The Planning Inspectorate  
National Infrastructure Planning  
Temple Quay House  
2 The Square  
Bristol  
BS1 6PN

**Our ref:** WX/2019/133441/01-L05  
**Your ref:** TRO40011  
**Date:** 23 November 2020

**METROWEST PHASE 1 DEVELOPMENT CONSENT ORDER (DCO) APPLICATION  
EXAMINATION DEADLINE 2 – SUBMISSION OF WRITTEN REPRESENTATIONS  
ENVIRONMENT AGENCY REFERENCE 20025331**

2.41 - Easton-in-Gordano Flood Mitigation Plan

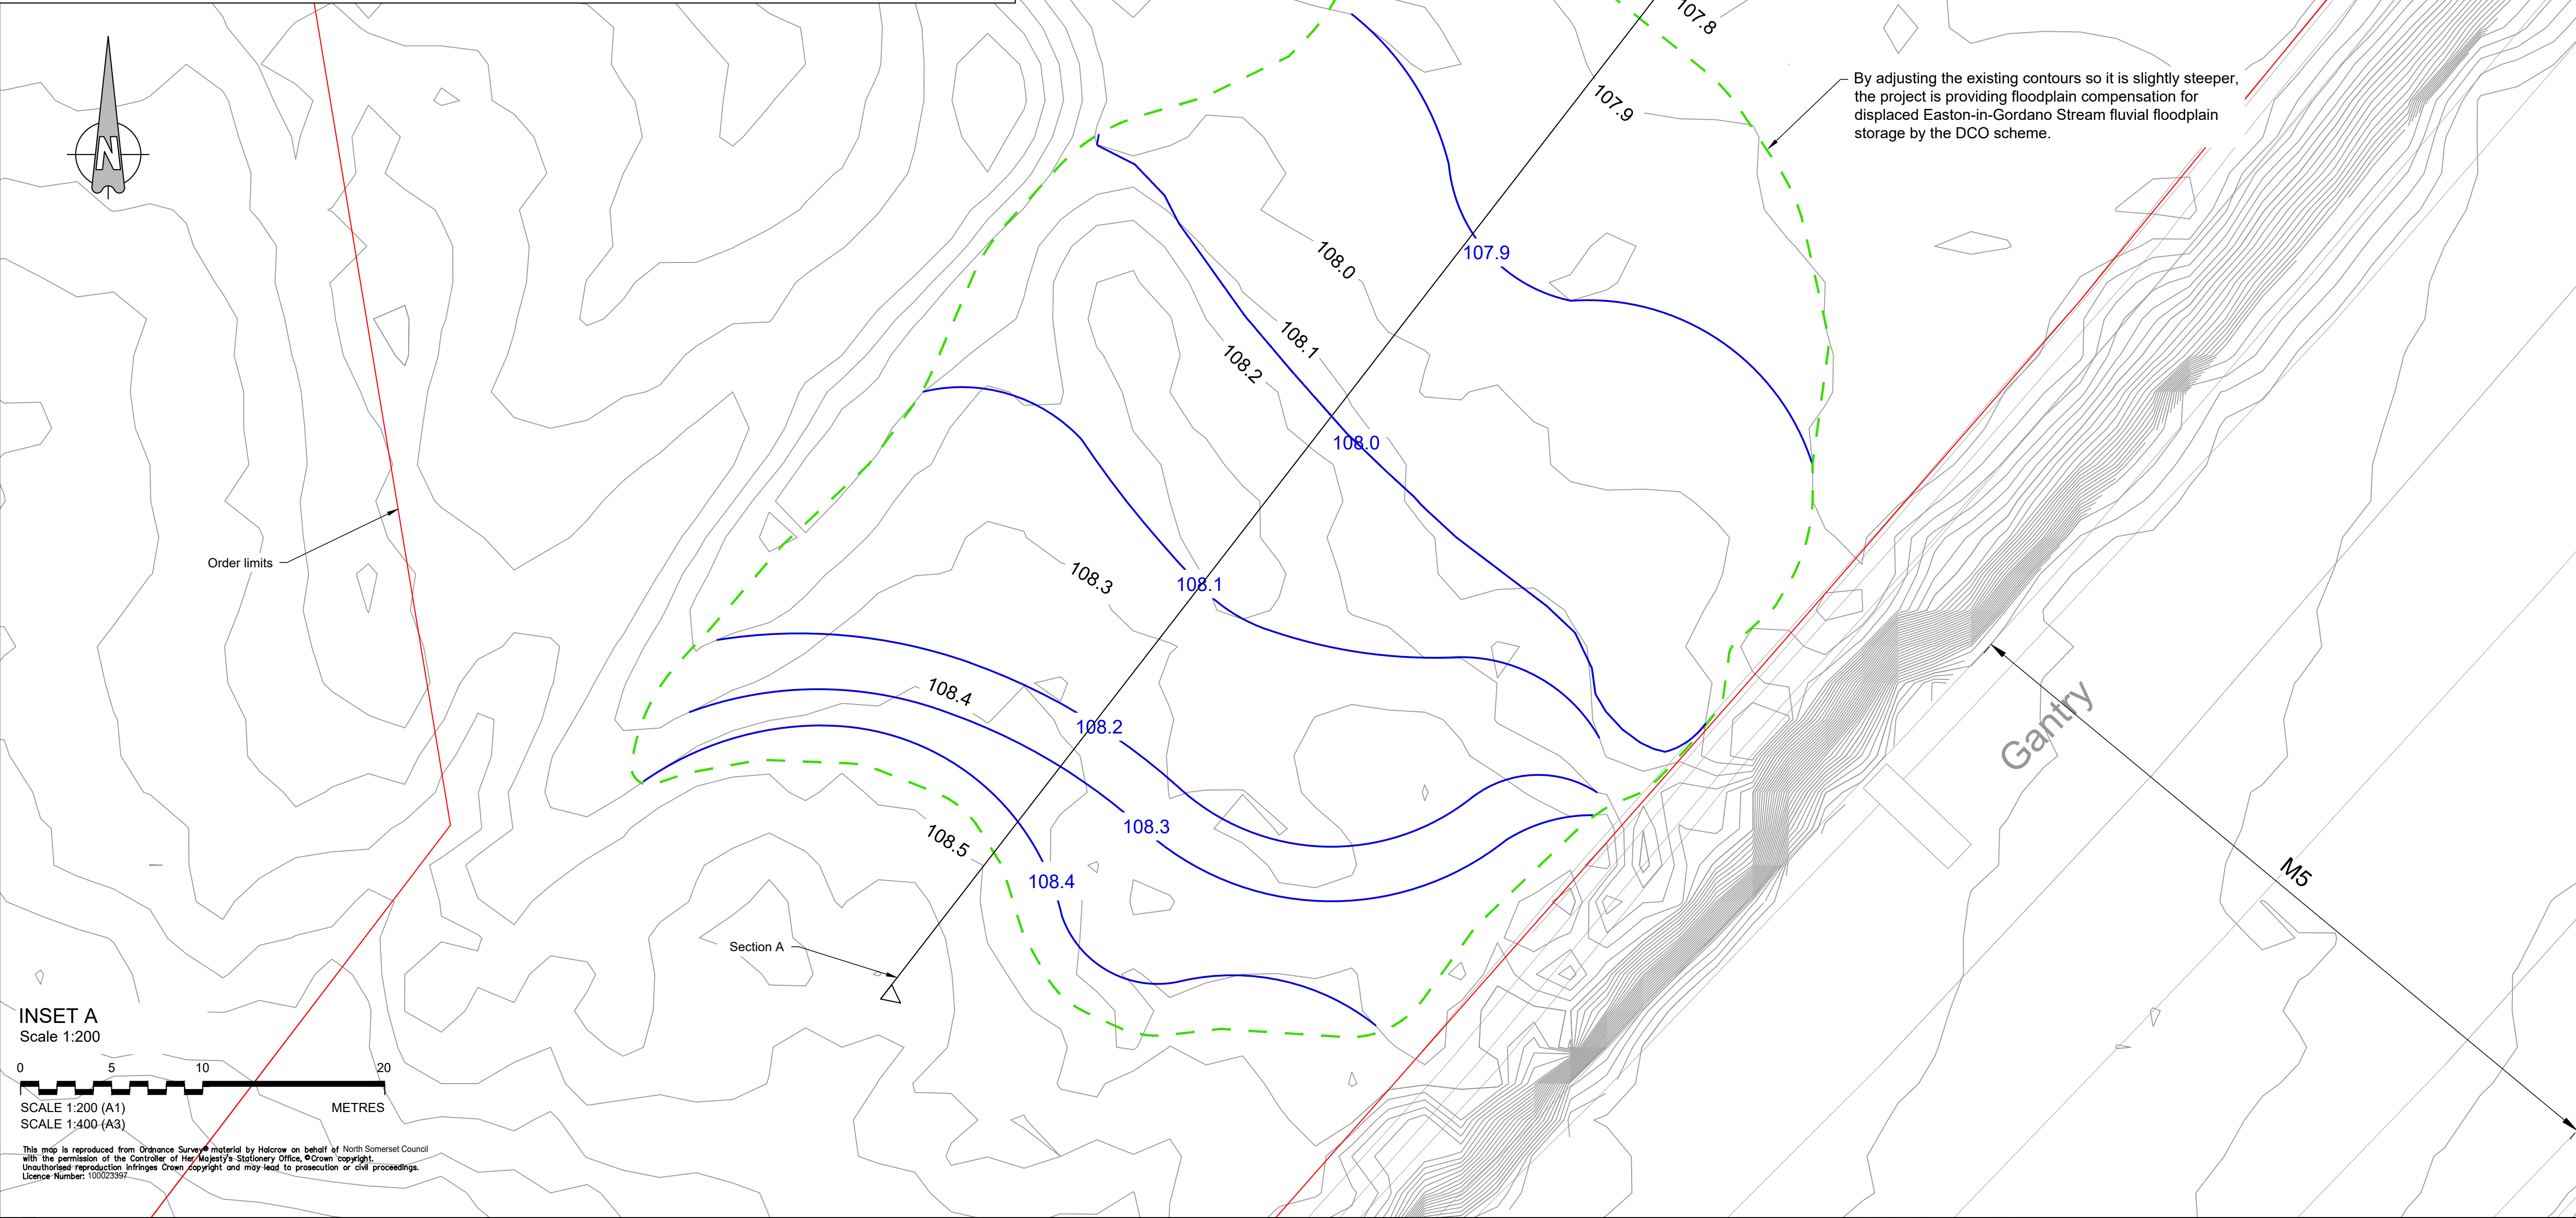
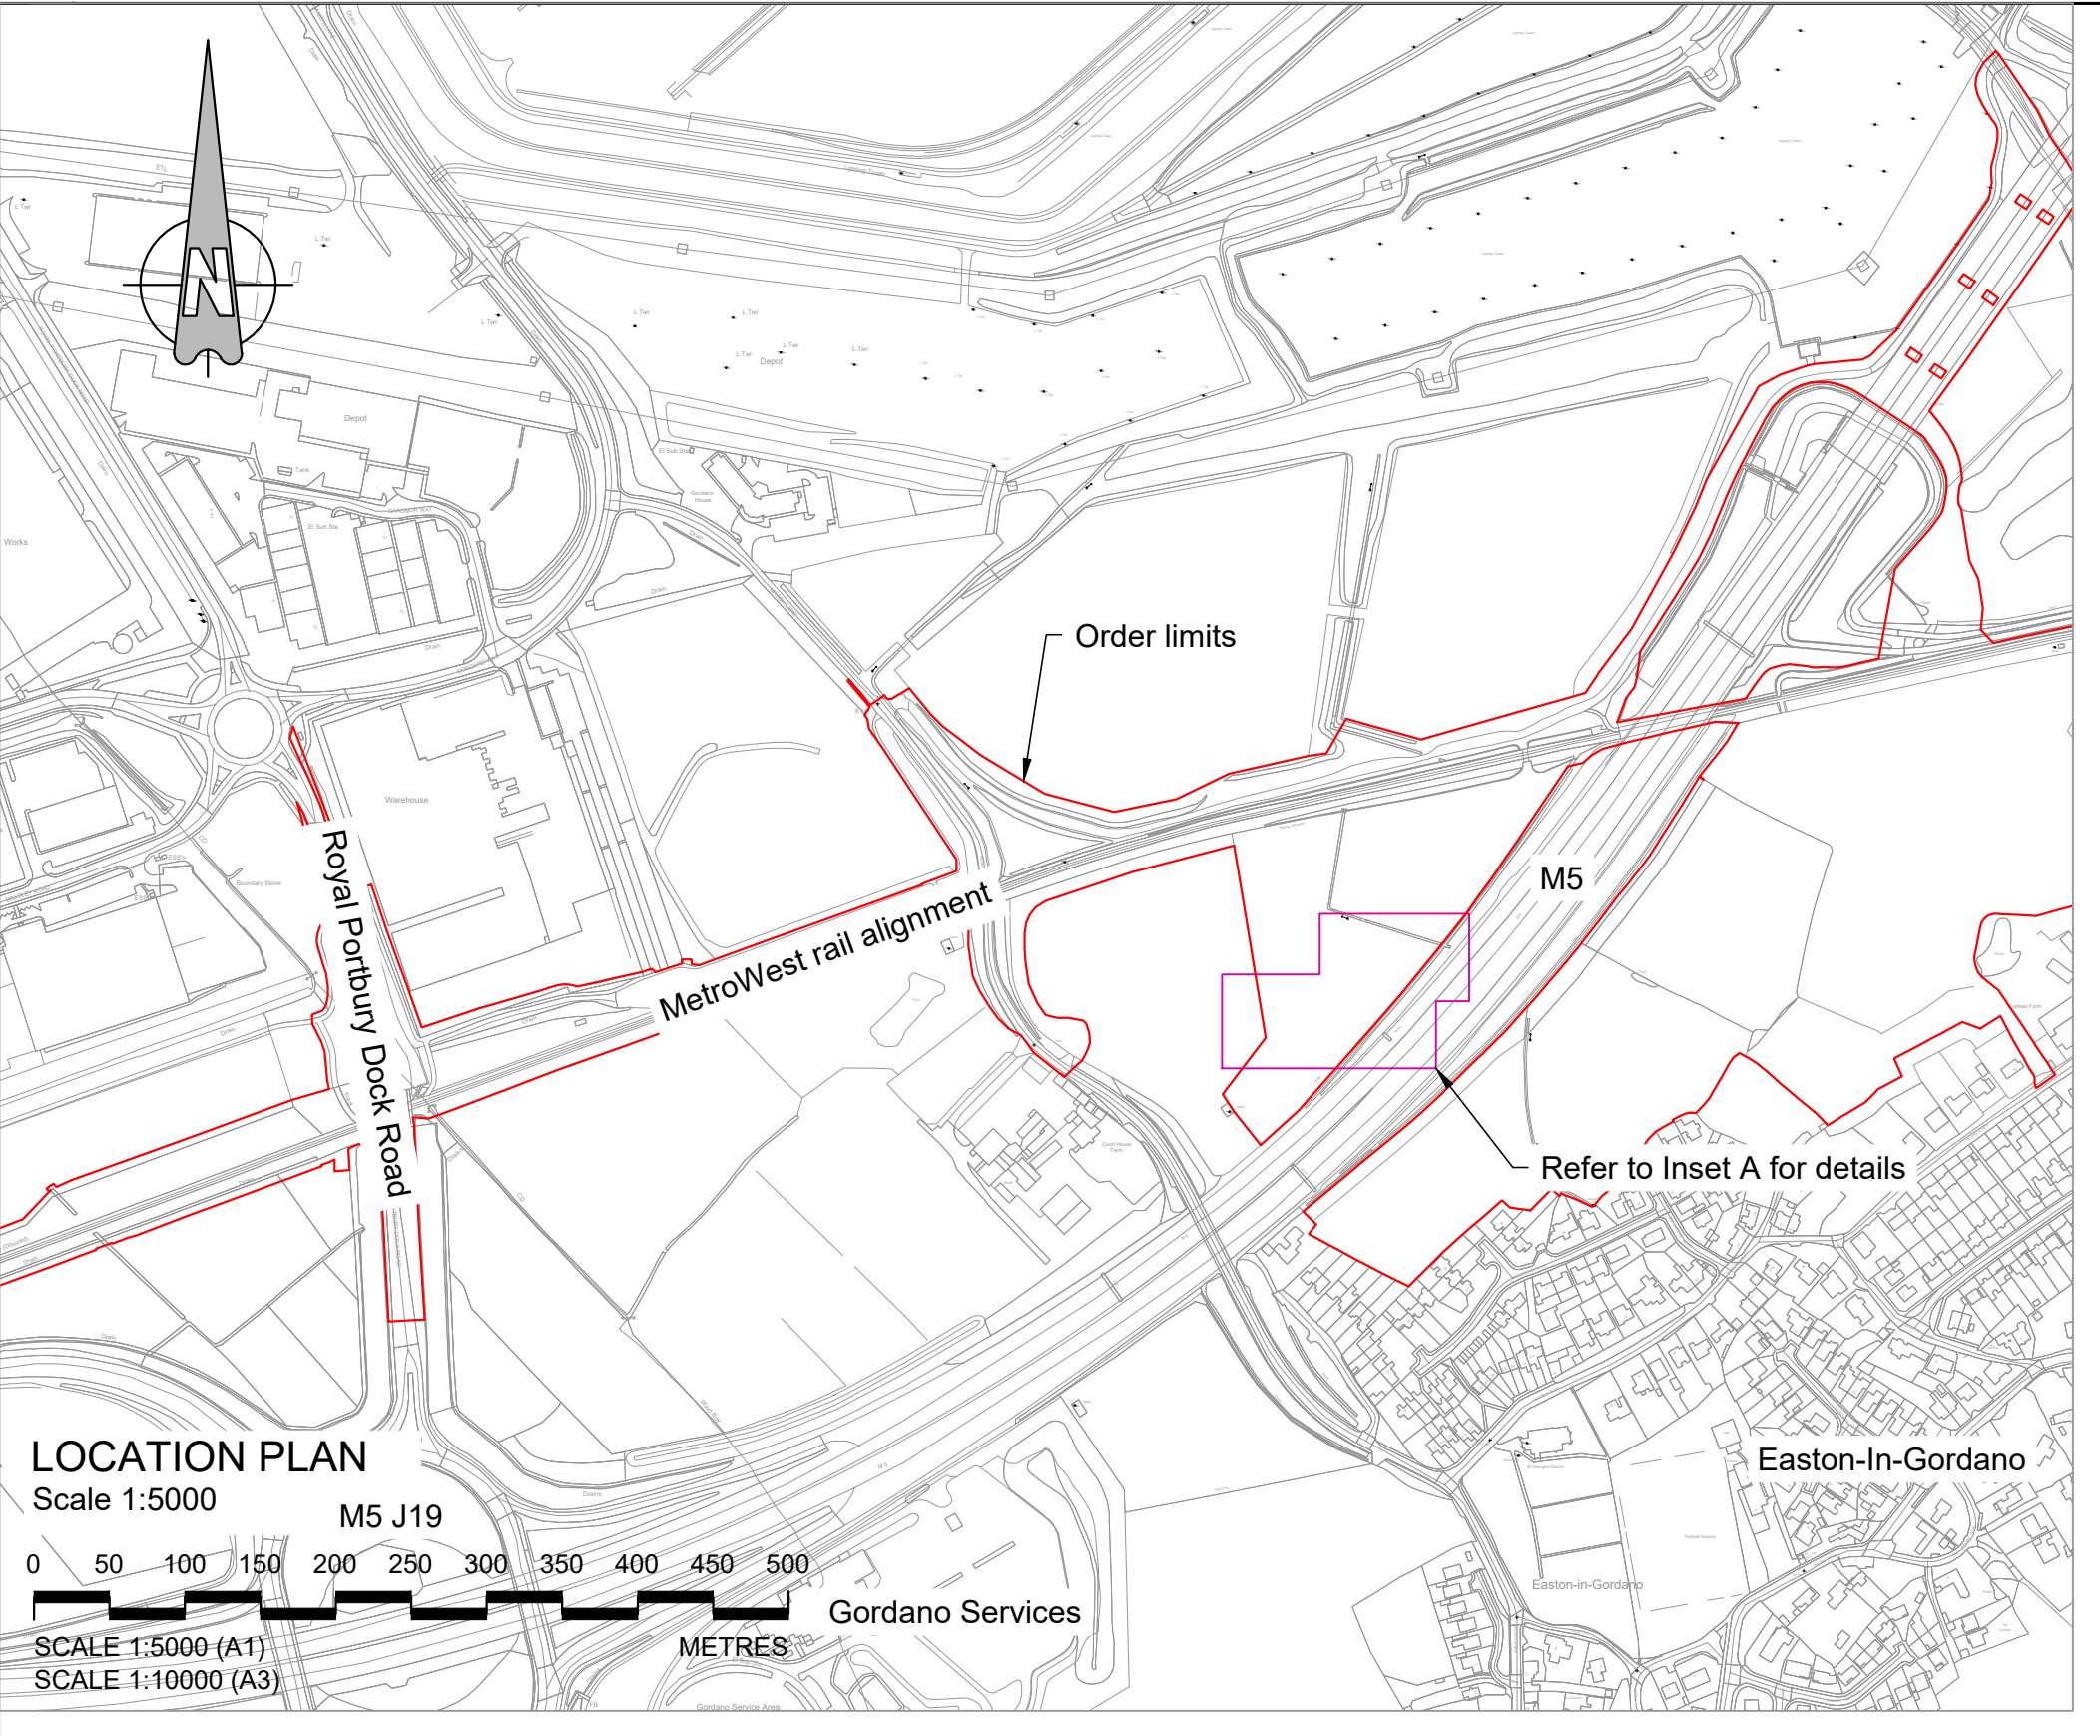
The FRA concludes the Portishead to Pill section of the scheme is above the fluvial and tidal 1 in 1000 year flood level, for present and future scenarios (2075 and 2115). However, this relies on a flood relief channel in the form of a farm access track running under the railway line. As a result, appropriate provisions are required within the DCO, to ensure the farm access track will be maintained for the lifetime of the development.

At that location, the railway needs to be realigned, which will result in a loss of floodplain storage. The model has identified a loss of floodplain storage of 75.5 m<sup>3</sup> as a result of realigning the railway.

Following the submission of the FRA and the model for review, a telephone conference between the Agency, Bristol Port and the applicant's representatives, took place on 20 Oct 2020, to discuss the floodplain compensation issue. On the basis of the identified volume of lost floodplain storage (75.5 m<sup>3</sup>) the Agency confirmed that it would not require the provision of floodplain compensation. Accordingly, all relevant supporting documentation, including the FRA and model report, must be updated to reflect the outcome of the meeting.
